3/7/2018

**RE: 9 Moody Street Residence, Portland, ME
City Review Comments Response #1**

R6 DESIGN STANDARD COMMENTS

SITE PLAN COMMENTS

SITE & GRADING PLAN

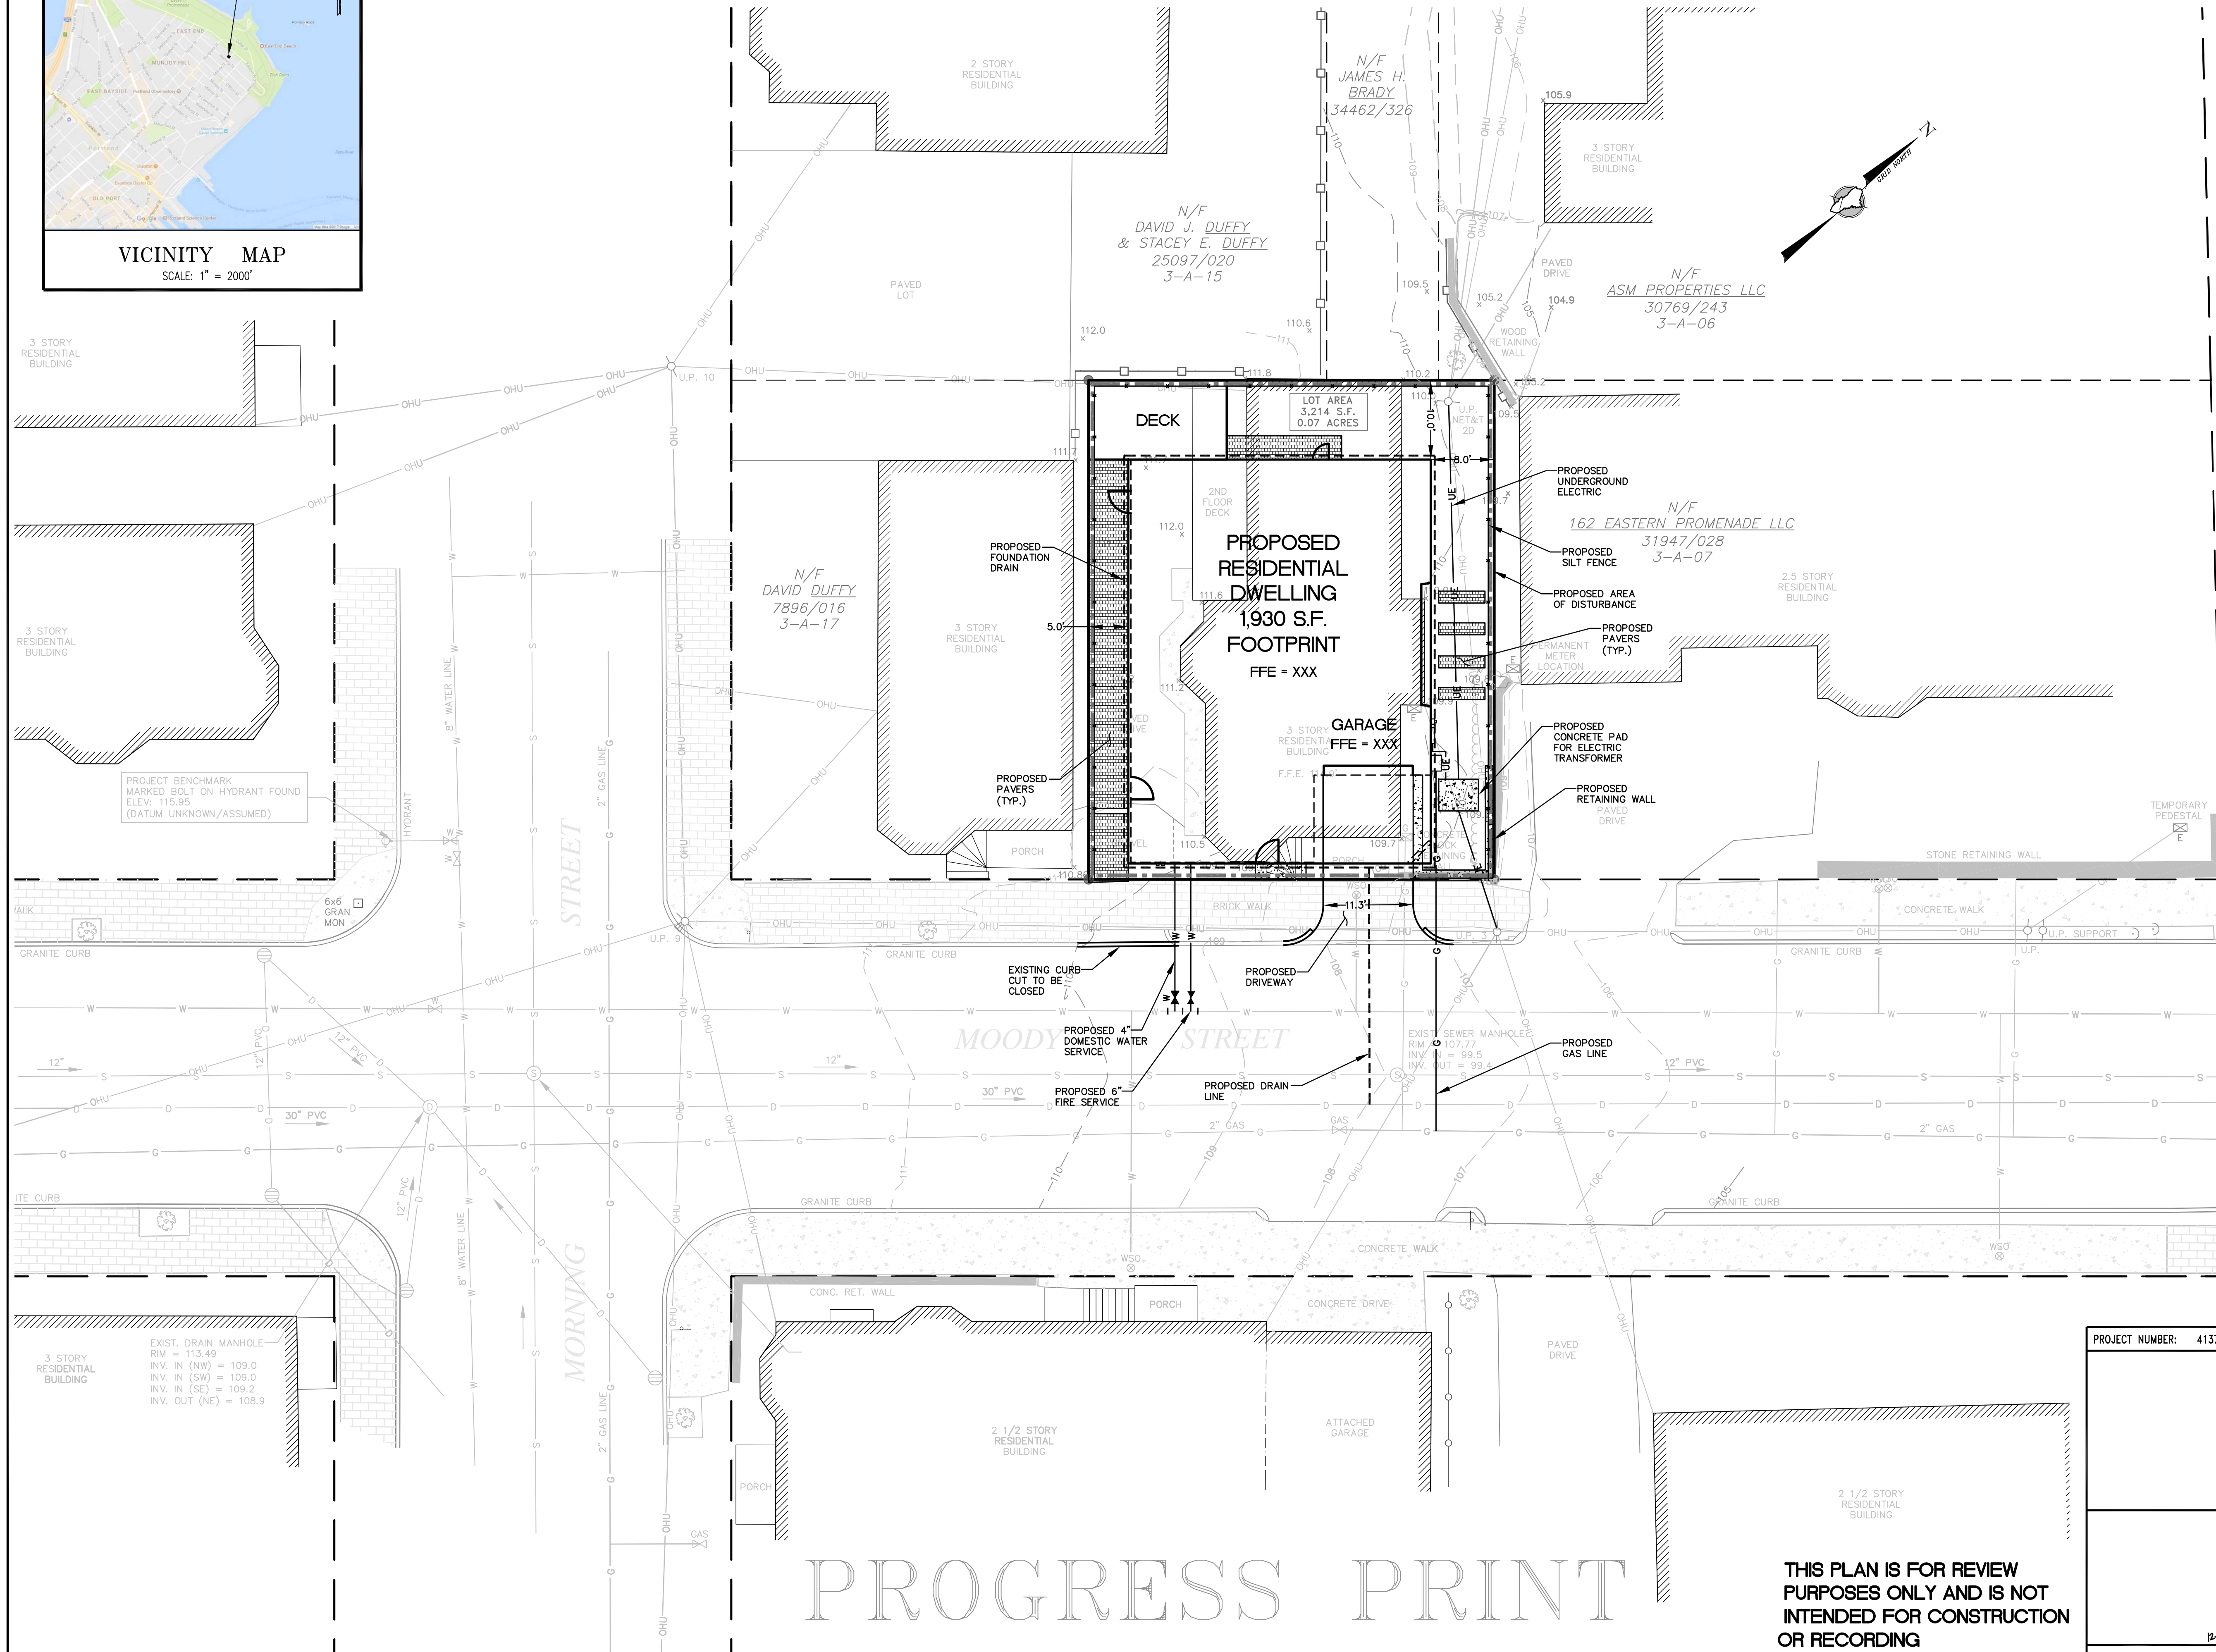
2. Add the ground floor areas and the finished floor elevation to the site plan. [\[CJS Response\] Revised Drawings from Civil Engineer with this information has been provided.](#)

3. Add the location of the sewer lateral from the street to the structure, to the site plan. [\[CJS Response\] Revised Drawings from Civil Engineer have been provided.](#)

4. Add to the site plan, the required erosion control measures i.e. silt fence or erosion control mix (erosion control plan) in the appropriate areas. [\[CJS Response\] Revised Drawings from Civil Engineer have been provided.](#)

7. Add to the site plan the sewer service lateral location. [\[CJS Response\] Revised Drawings from Civil Engineer have been provided.](#)

8. Moody Street is a moratorium Street. Show the limits of the moratorium street repair on the site plan. [CJS Response] Revised Drawings from Civil Engineer have been provided.

10. Provide grading information, including spot grades for the entire site, including the elevations of the retaining wall. [CJS Response] Revised Drawings from Civil Engineer have been provided.

SITE & GRADING PLAN

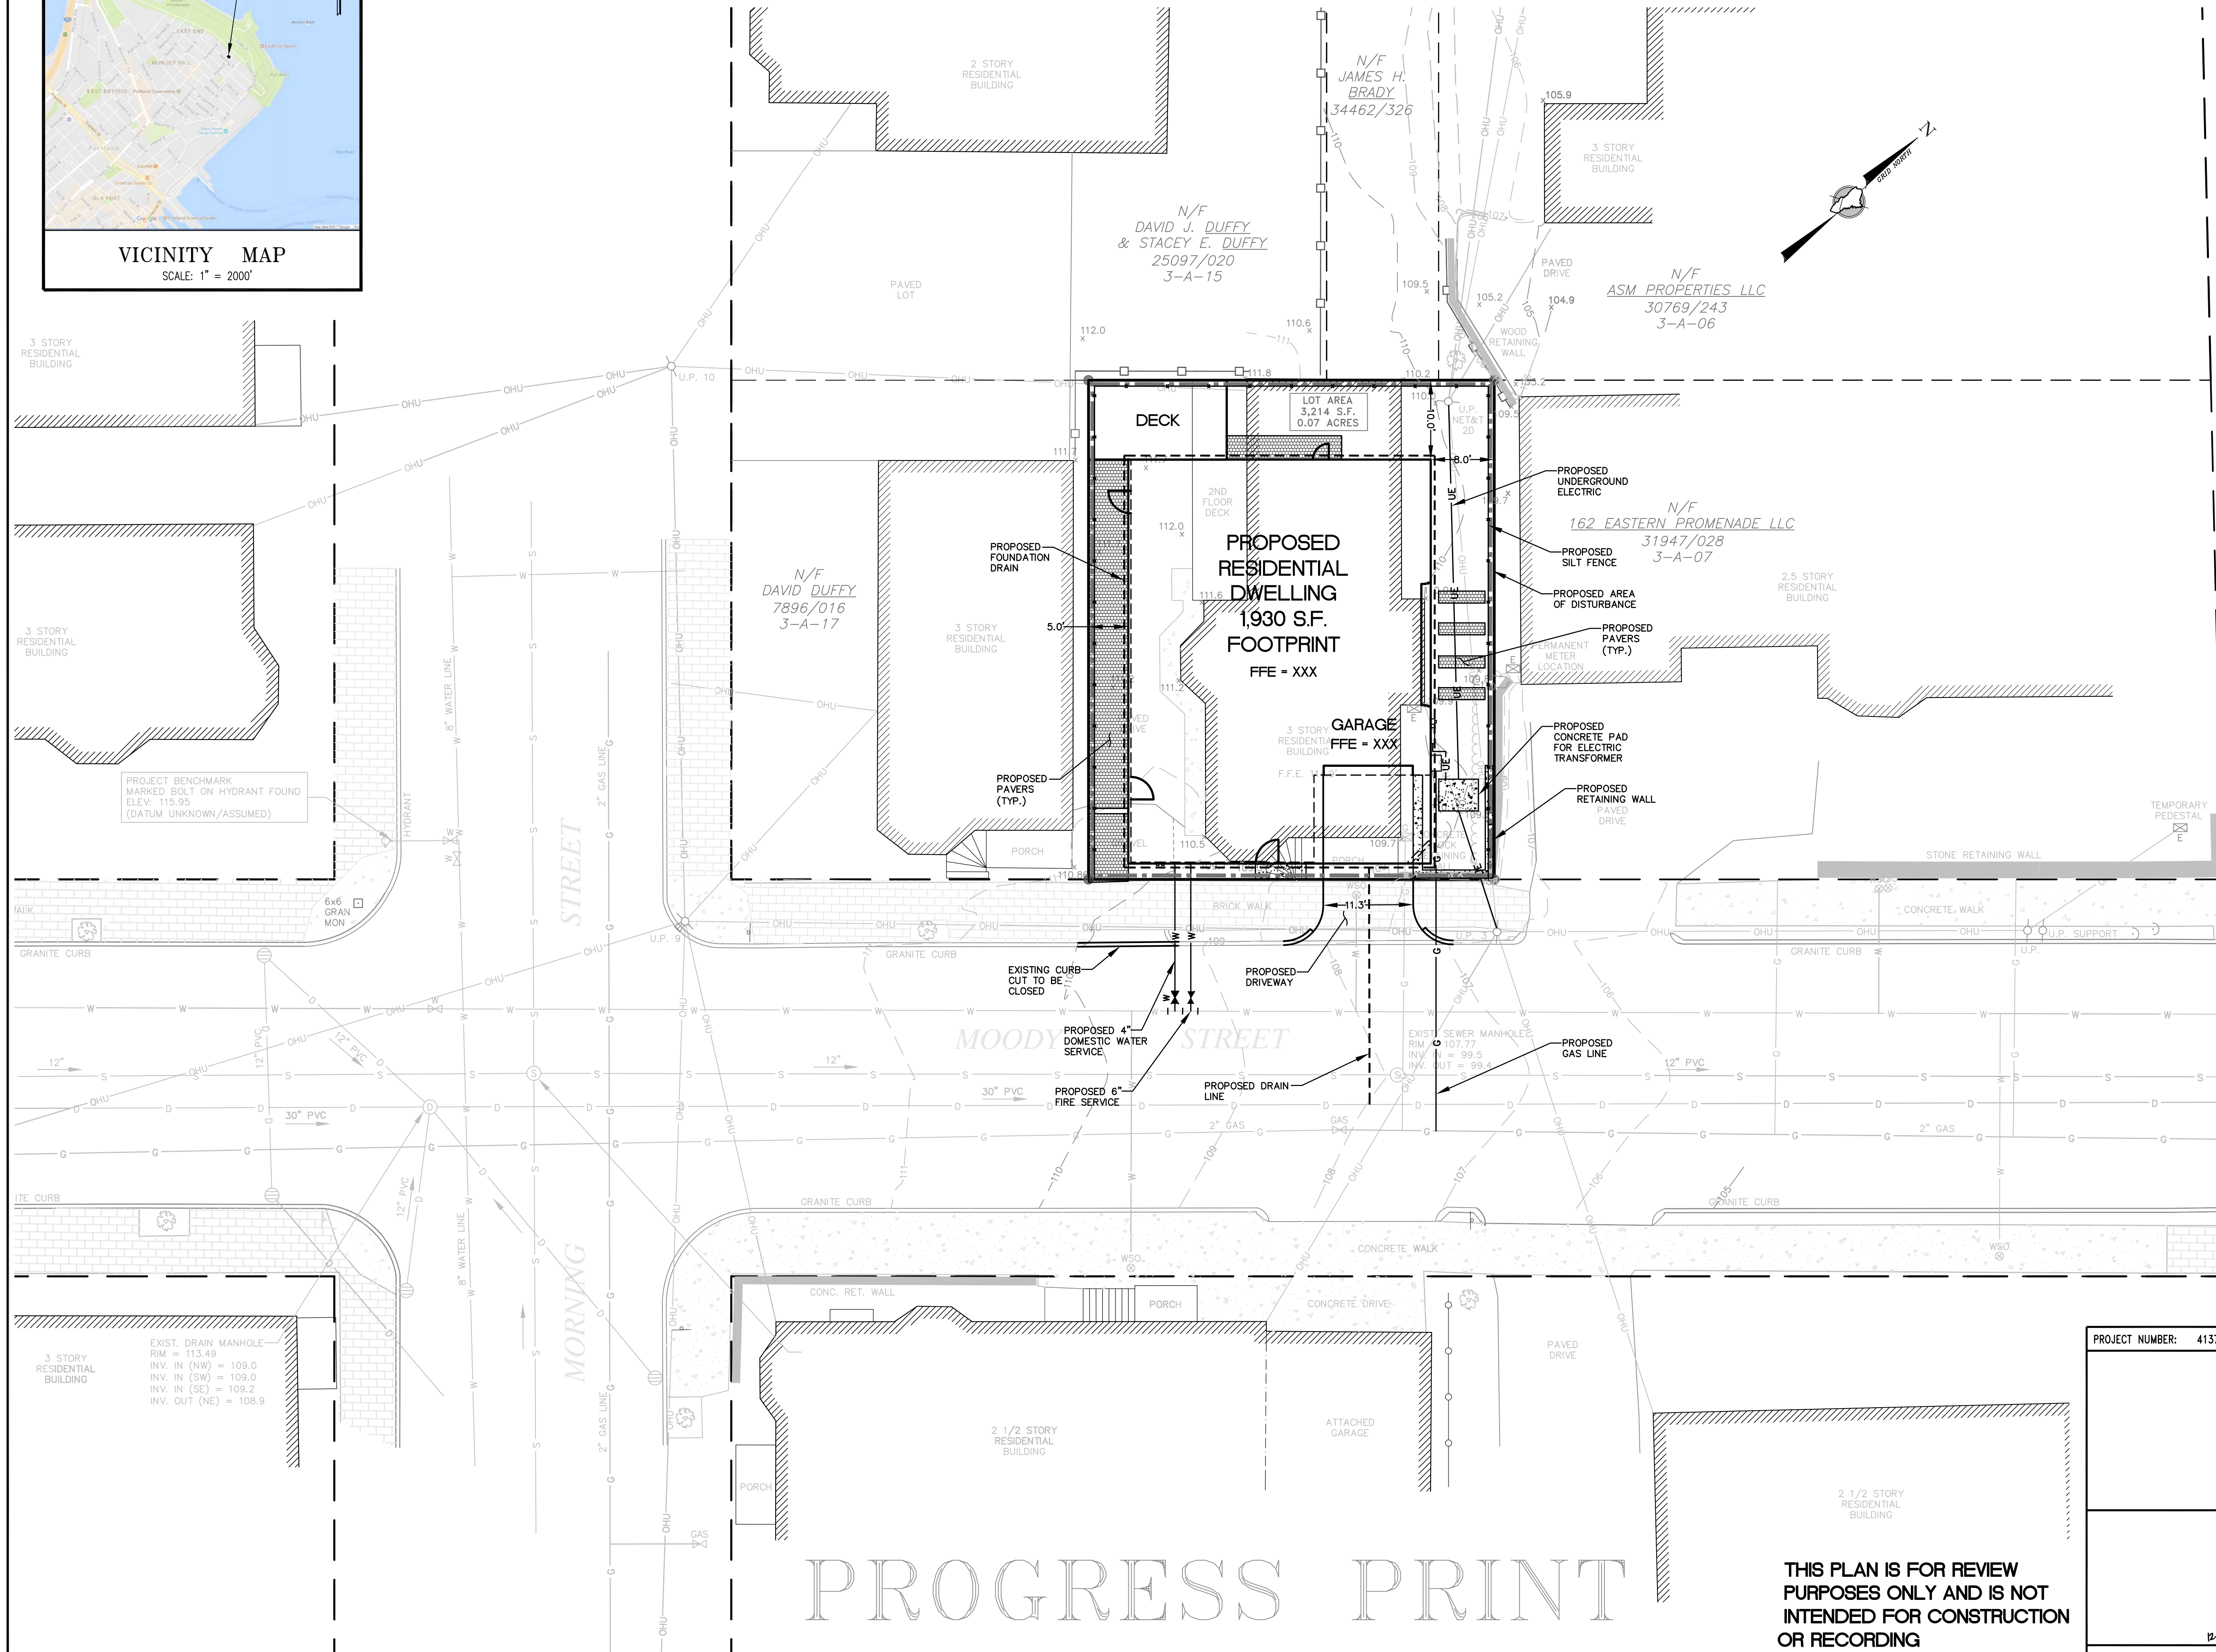
1. The City's Technical Manual requires a minimum 20 feet of separation between driveways, measured at the property line. The site plan must be revised to comply with this standard. [\[CJS Response\] Please see attached waiver request prepared by the Civil Engineer, Northeast Civil Solutions. We have received staff support previously from via an email received from Jeremiah Bartlett to the design team dated Oct 19th, 2017.](#)

5. Add to the site plan 1 additional street tree along the street frontage, meeting the City's minimum arboricultural standards. [\[CJS Response\] Please see attached waiver request prepared by the Civil Engineer, Northeast Civil Solutions. As a matter of clarification, due to the new duct bank under the sidewalk the single tree in the public-right-of-way will not be possible. Please disregard the tree shown on Landscape Drawings and refer to Civil Drawings where no tree is shown.](#)

11. Show the roof drainage connection. [CJS Response] Revised Drawings from Civil Engineer have been provided. Please also see revised Architectural Drawings showing roof drain and rain leader locations

12. Show where the oil/water separator will be located, its connection to the floor drains and the City system, and include a detail of the unit. [CJS Response] Floor drains have been removed from inside garage in order to avoid the need for an oil/water separator. There will be a stormwater drain outside in the concrete strips by the side garage door at the East property line. This will then connect to rain leaders under the garage slab. Refer to revised Architectural and Civil drawings.

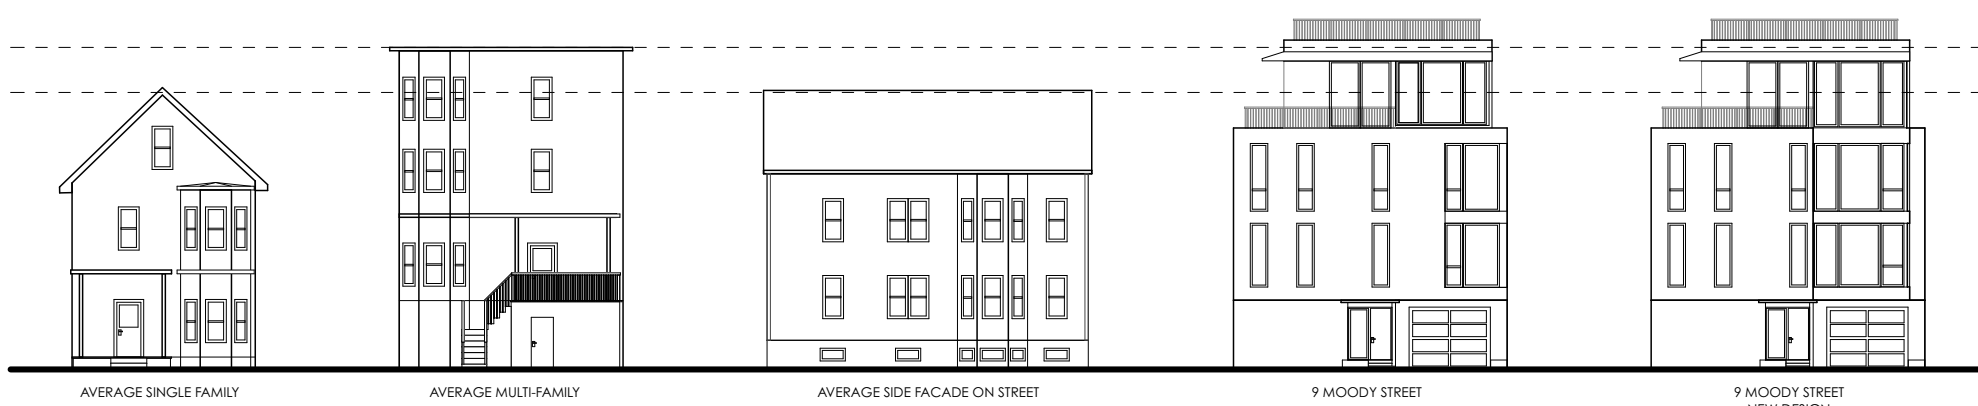
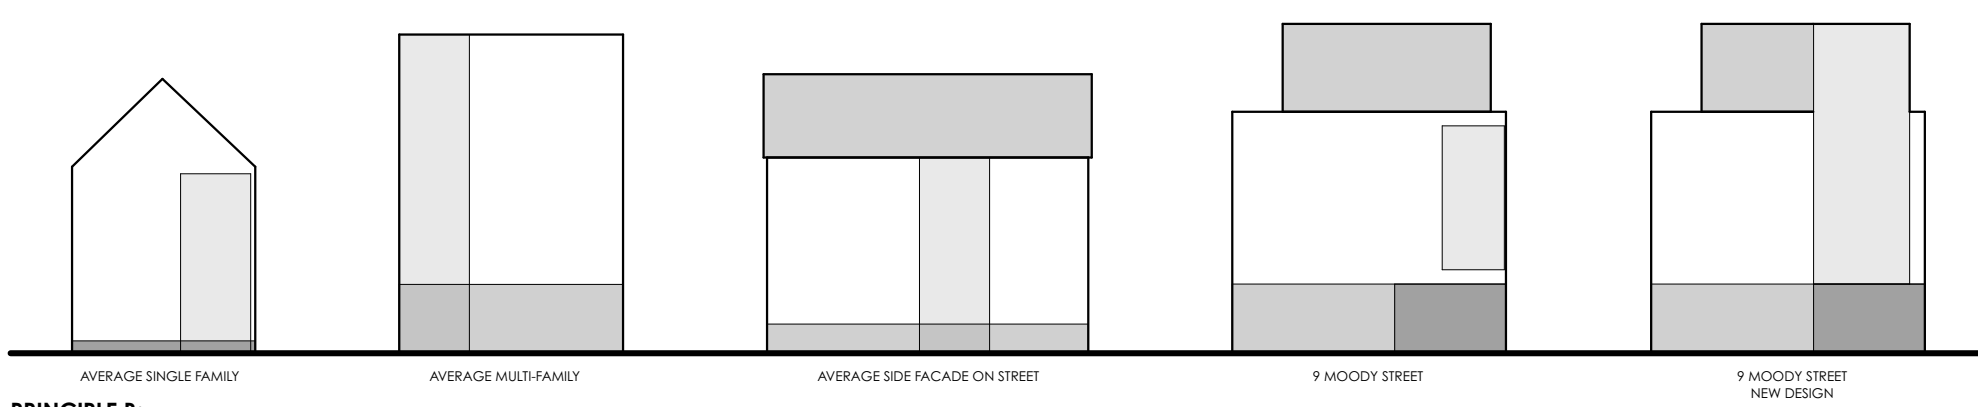
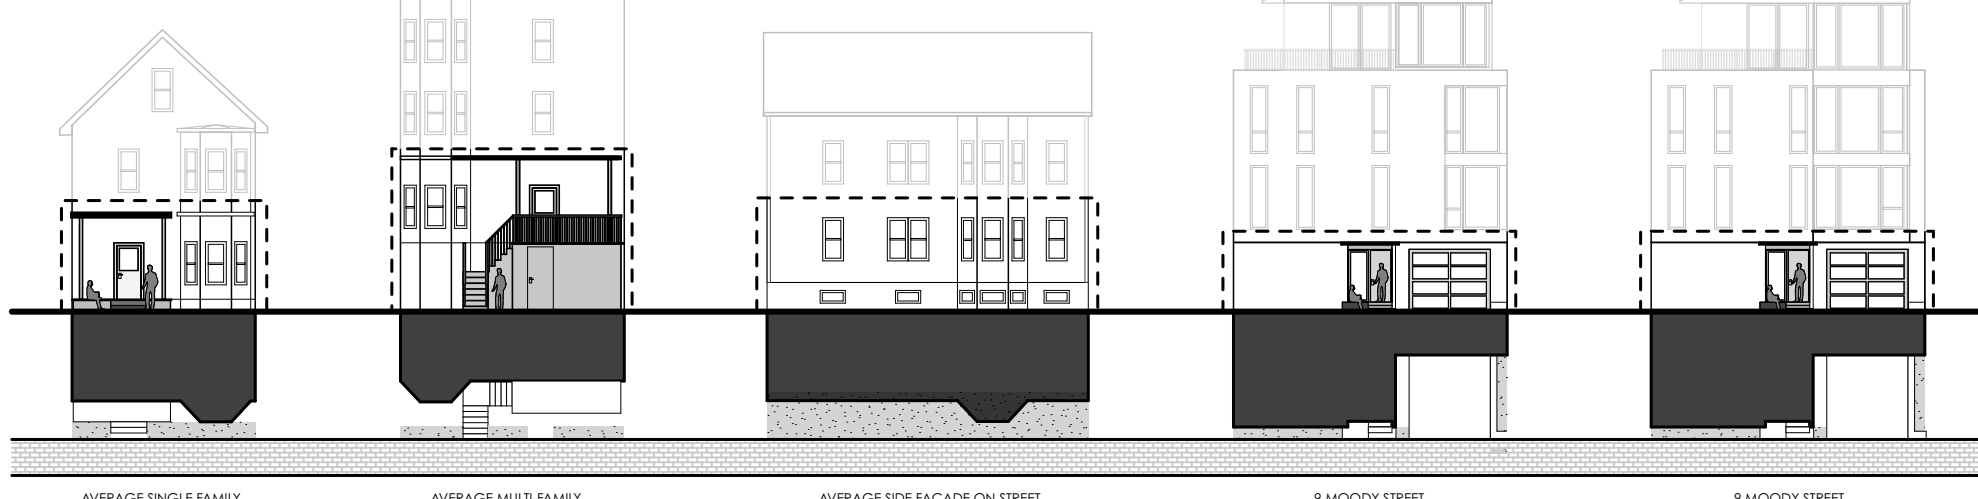
[CJS Response and Commentary] CJS made revisions to the initial design based on comments obtained from the February 1st email, these comments have been incorporated directly onto sheet G-003. We held an in-person meeting with Caitlin on February 6th and made further revisions afterwards. We sent this revised design via email to Caitlin and received a proceed notice from staff via email from Caitlin on February 8th. We have uploaded revised complete set of drawings reflecting the latest design revisions addressing staff review.
